# Charlotte Department of Transportation

## Memorandum

**Subject:** Rezoning Petition 08-093: Located at the intersection of Lancaster Highway and Johnston Road  
(revised 6/21/08)

01 TECHNICAL DATA SHEET

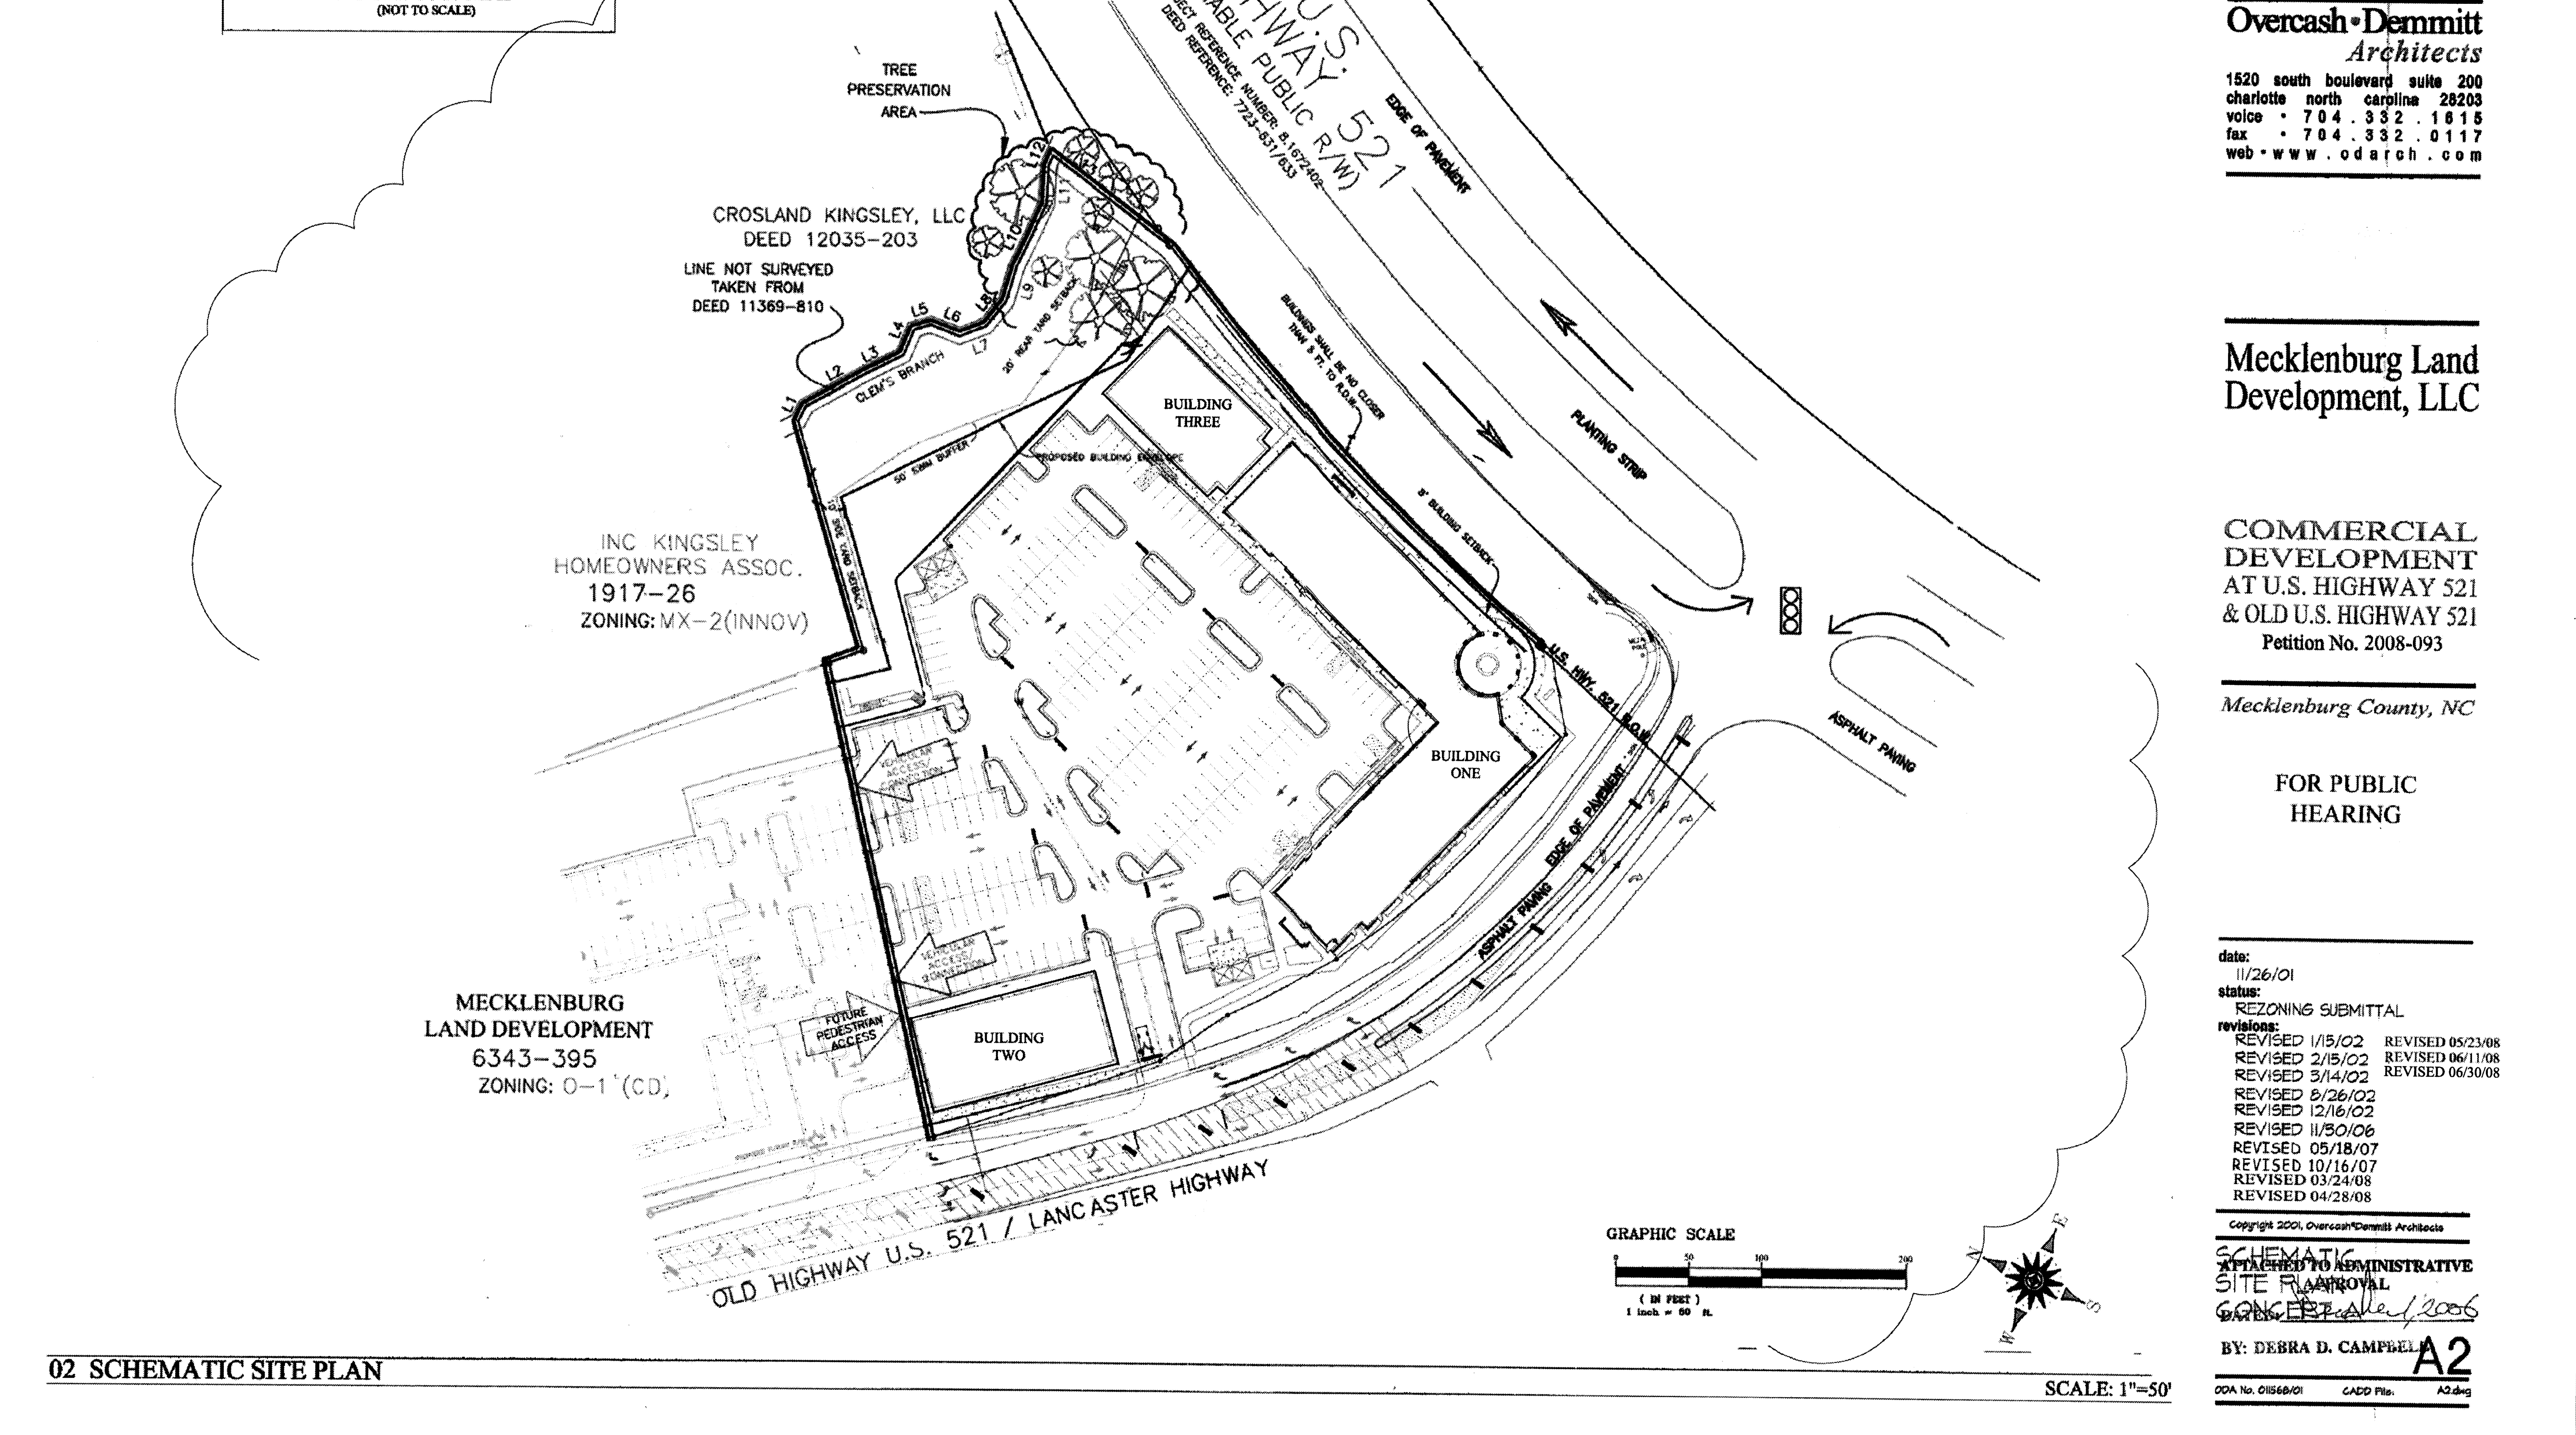
1. Public street sidewalks (whether in the right-of-way or on private property on an easement) must be ADA compliant. Steps will not be allowed in the right-of-way. Steps will be allowed in an easement provided that there is a corresponding accessible ramp adjacent to the steps. (*Previous review comment*)
2. Sidewalks (external to the development) must be provided along the entire length of all public streets. However, the developer may locate and meander the sidewalk beyond the

standard 8' planting strip in order to preserve existing trees. The note concerning the termination of sidewalk at the tree save area needs to be deleted. (*Previous review comment*)
